CITY OF ALBUQUERQUE

May 30, 2019

**RE: Albuquerque RV & Boat Storage
2201 Vista Oriente St. NW
Grading and Drainage Plan
Engineer's Stamp Date: 05/20/19
Hydrology File: H09D030**

**CG-101**  
SH. OF

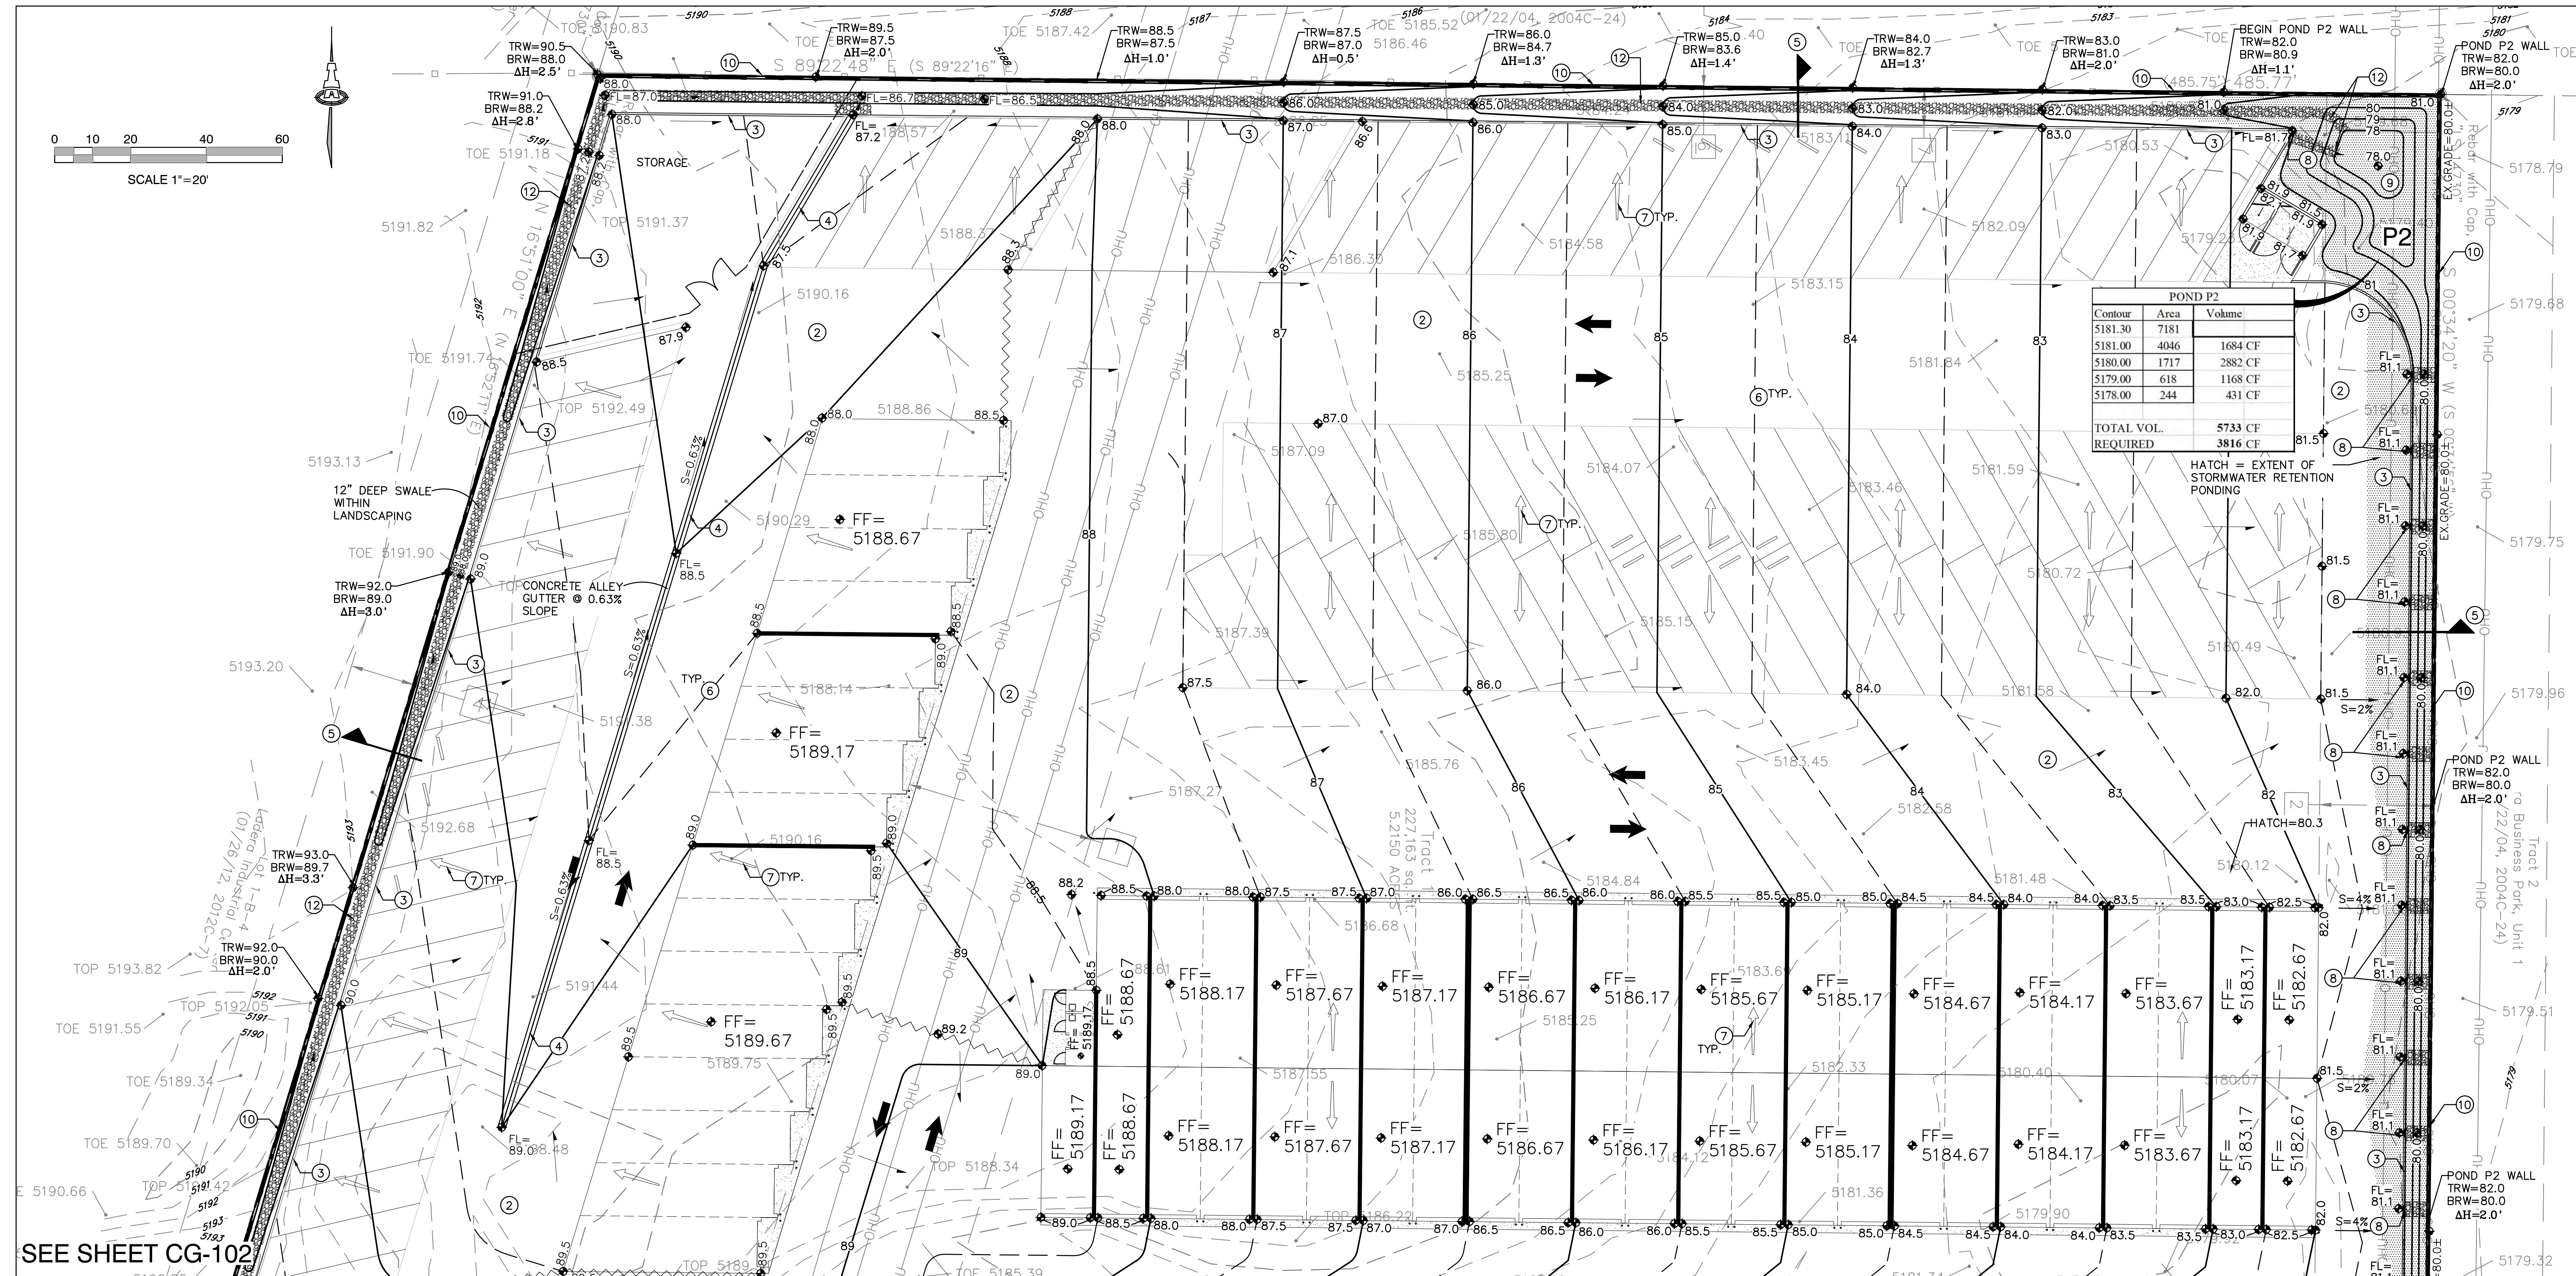
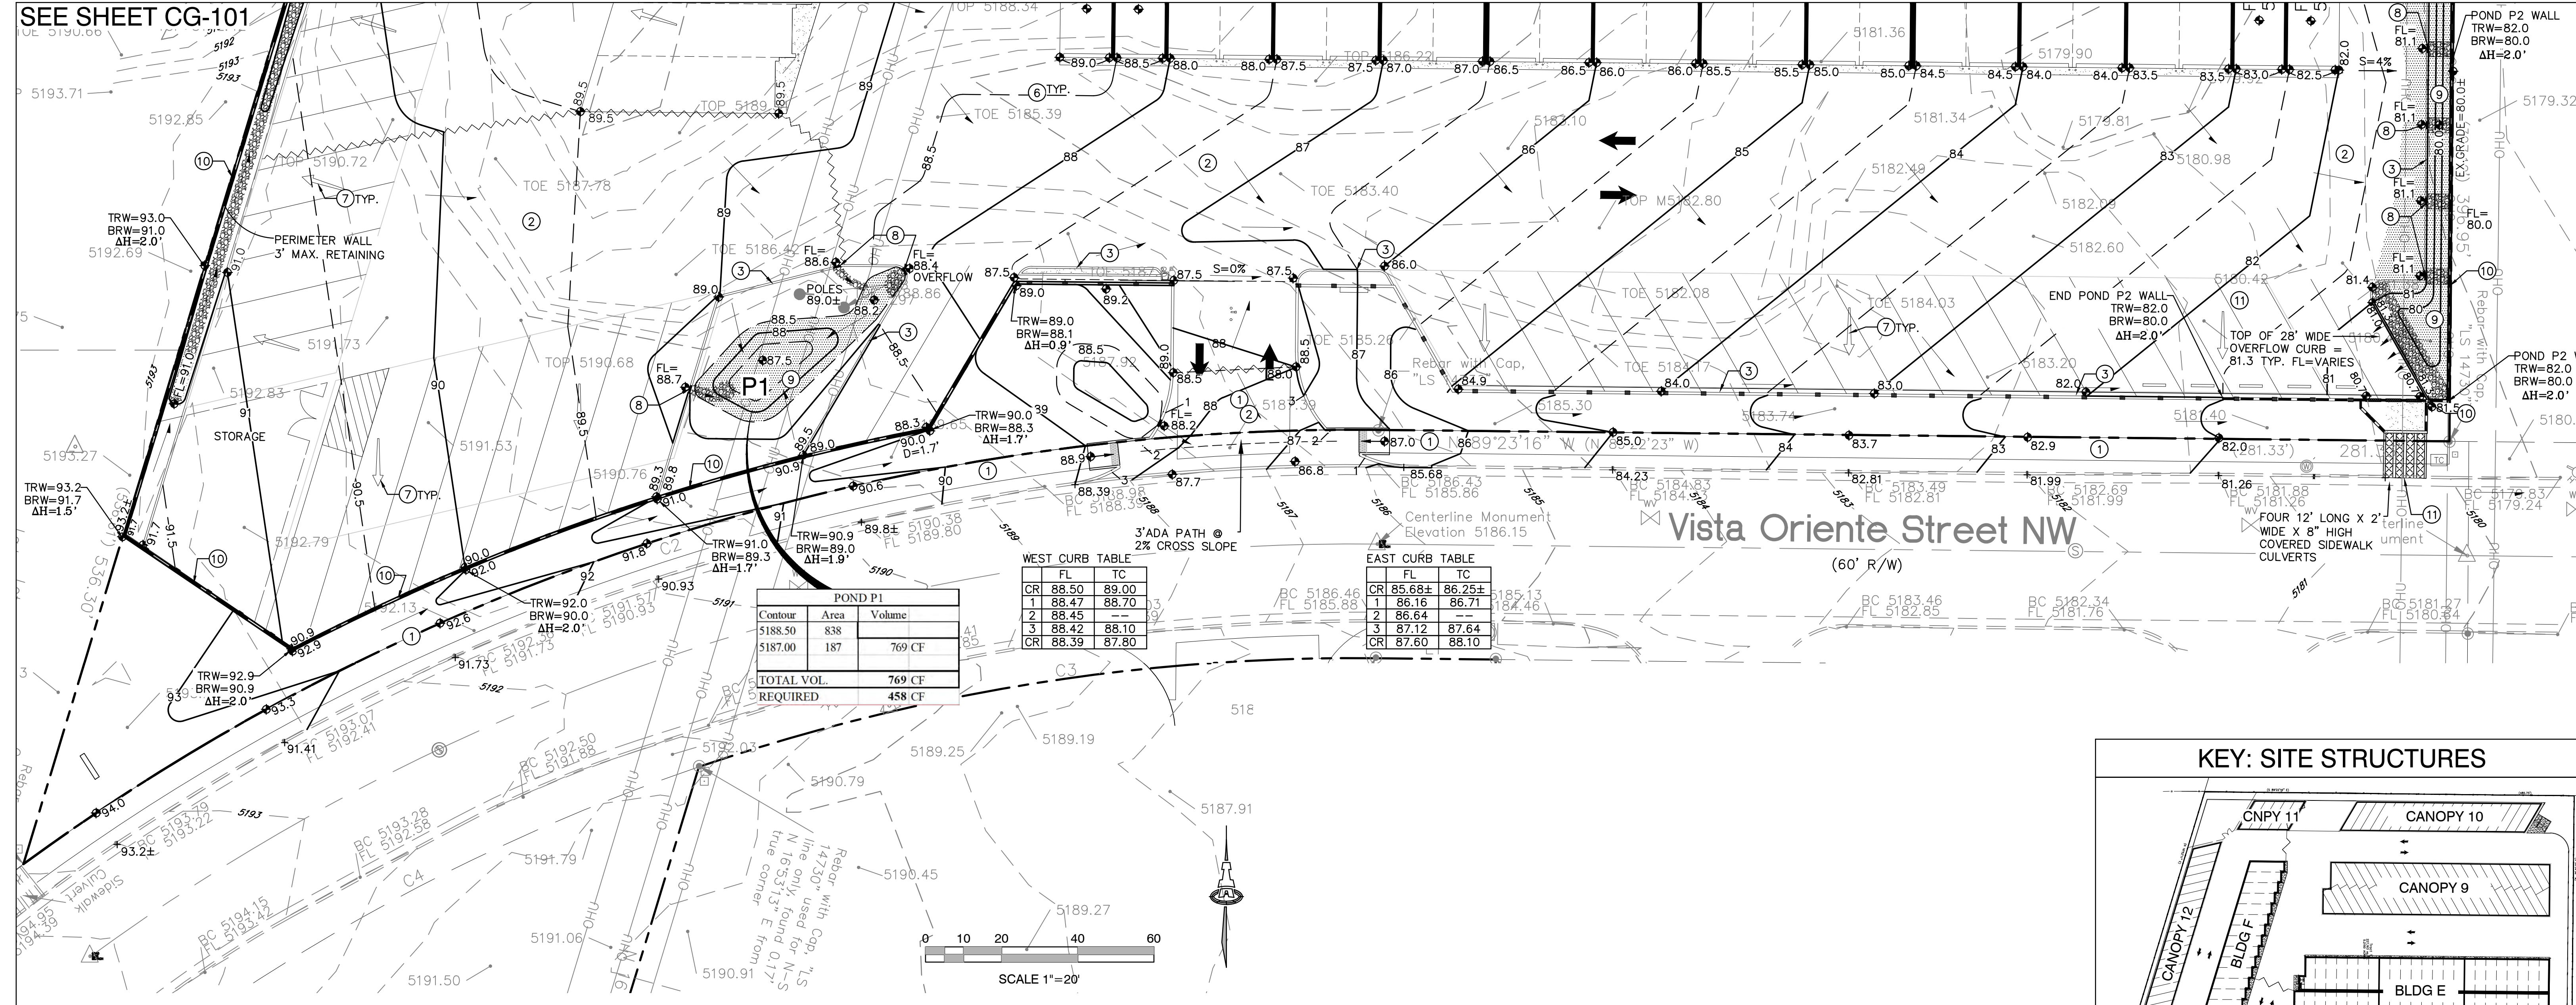
1. Please add sections of the proposed perimeter wall on the West and North property lines. This section should include the proposed perimeter wall along the property line, the proposed gravel swale, the location of the wall's footer (this needs to stay within the property) and the proposed grades on the other side of the wall.

2. Please add the reference to the City of Albuquerque standard detail No. 2236 for the sidewalk culverts.
3. Please correct the boarder on Sheet CG-101. It seems a little off.

## STORMWATER OUTFALL STRUCTURE TO VISTA ORIENTE

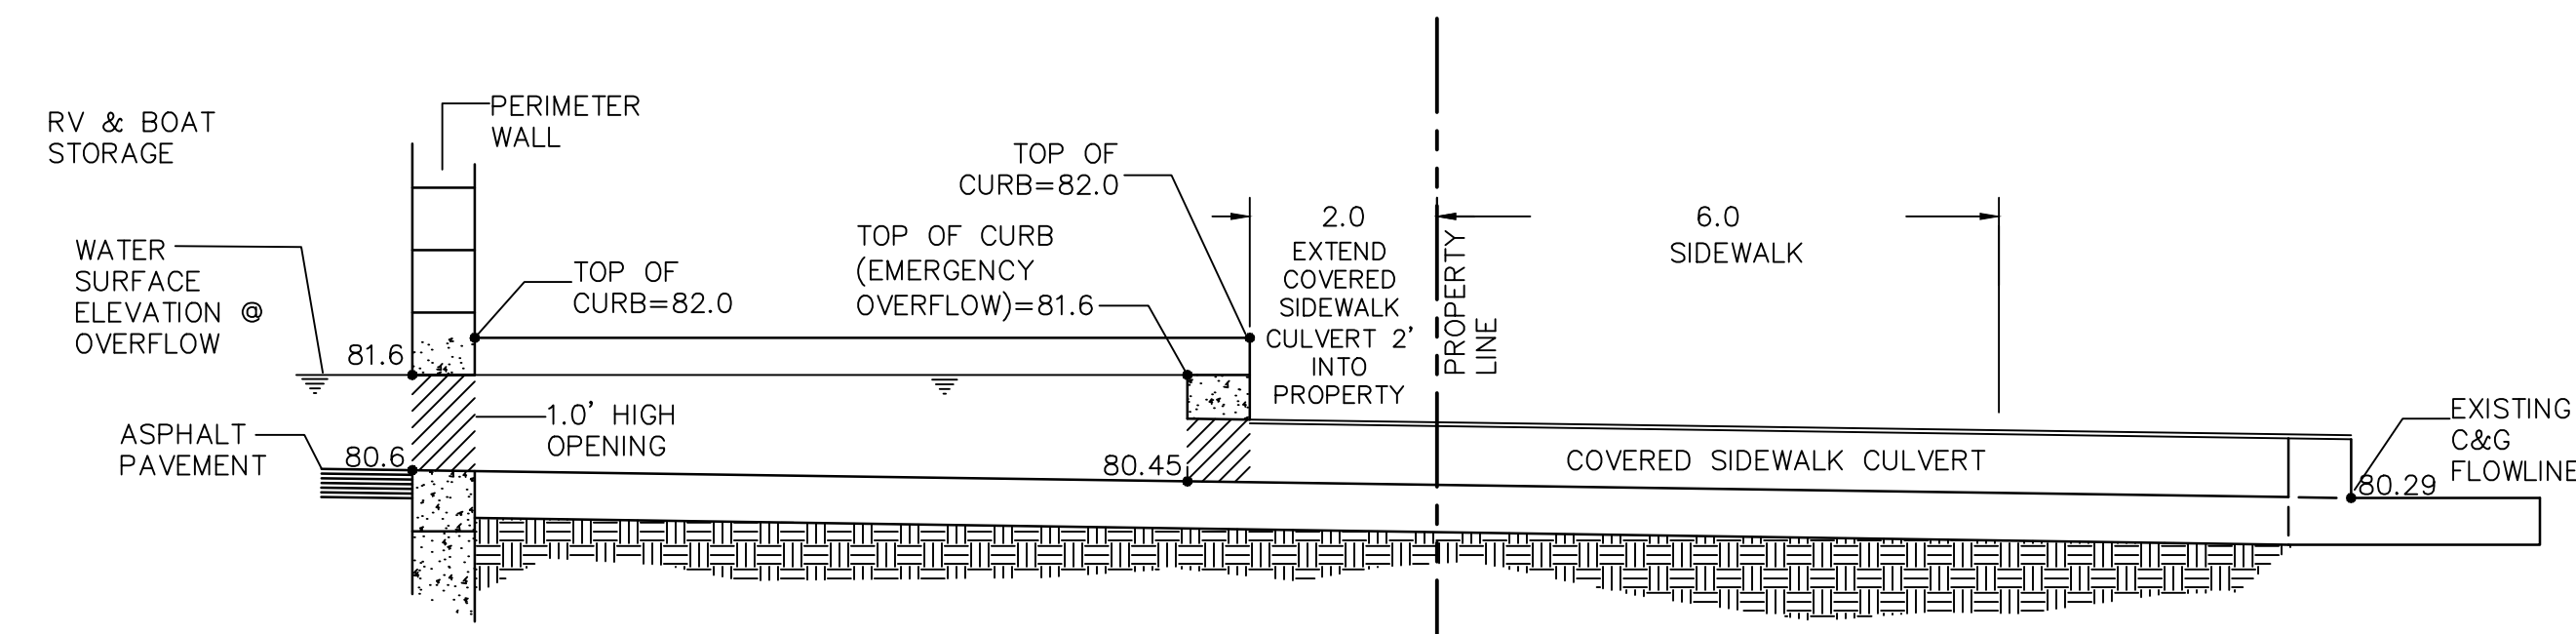
5. For the sidewalk culverts, instead of the orifice equation which was used, the broad crest weir equation ($Q = CLH^{2/3}$) with coefficient "C" =3 for a broad-crested weir must be used, not the orifice equation. Running both formulas reveals that the weir equation is the controlling equation for this application. Per, Handbook of Hydraulics, Brater and King, 6th Edition (1976), Table 5-5(a), a C coefficient of 3.06 is the most appropriate value, but anything in the 2.95 to 3.09 range would be reasonable. Even if the orifice equation governed, this application of the orifice equation erroneously uses h ranging from 0.74'

to 0.89'; per the DPM Ch.22, section 3, part A: h = Depth of water measured from the center of the opening, so h should be 0.292'. So if you use the weir equation, $Q = 4.19$ cfs per sidewalk culvert. If you use the orifice equation with the correct height, $Q = 3.23$ cfs per sidewalk culvert. So the site has a flow of 20.4 cfs, so you would need 5 – 2 ft sidewalk culverts. Please correct.

## WEIR CALCULATIONS

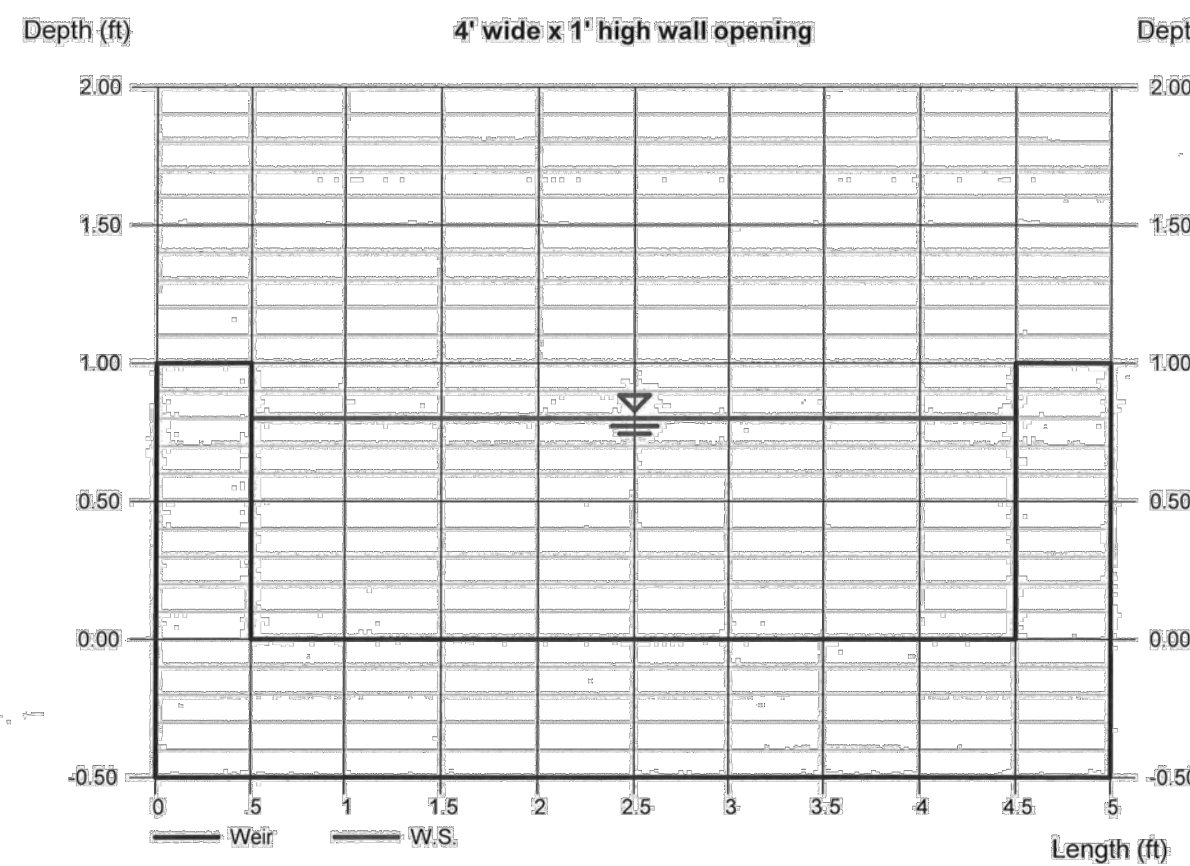
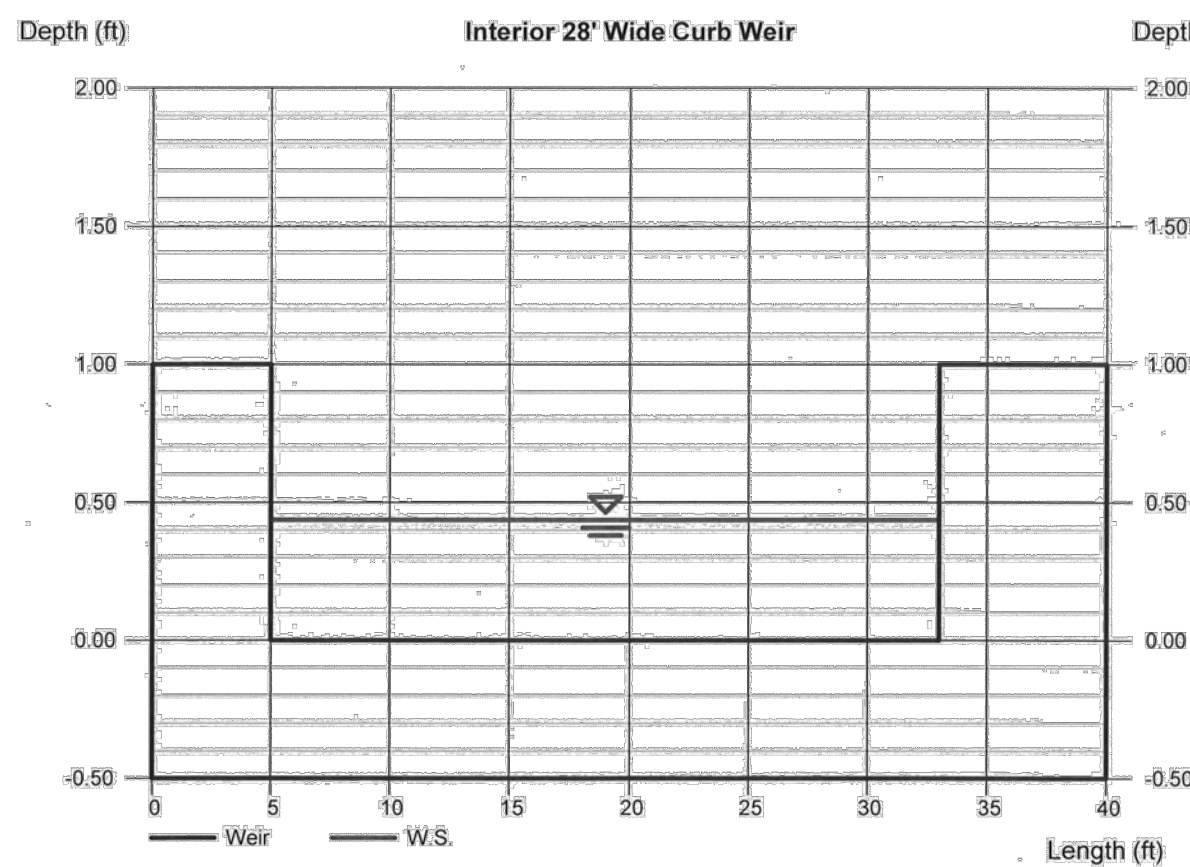
6. Please add the weir equation for the 28' emergency overflow spillway.
7. As a reminder, if the project total area of disturbance (including the staging area and any work within the adjacent Right-of-Way) is 1 acre or more, then an Erosion and Sediment Control (ESC) Plan and Owner's certified Notice of Intent (NOI) is required to be submitted to the Stormwater Quality Engineer (Curtis Cherne, PE, ccherne@cabq.gov, 924-3420) 14 days prior to any earth disturbance.
8. As a reminder, please provide a Drainage Covenant per Chapter 17 of the DPM for water quality ponds prior to Permanent Release of Occupancy. Please submit this on the 4th floor of Plaza de Sol. A \$25 fee will be required.
9. Standard review fee of \$150 will be required at the time of resubmittal.
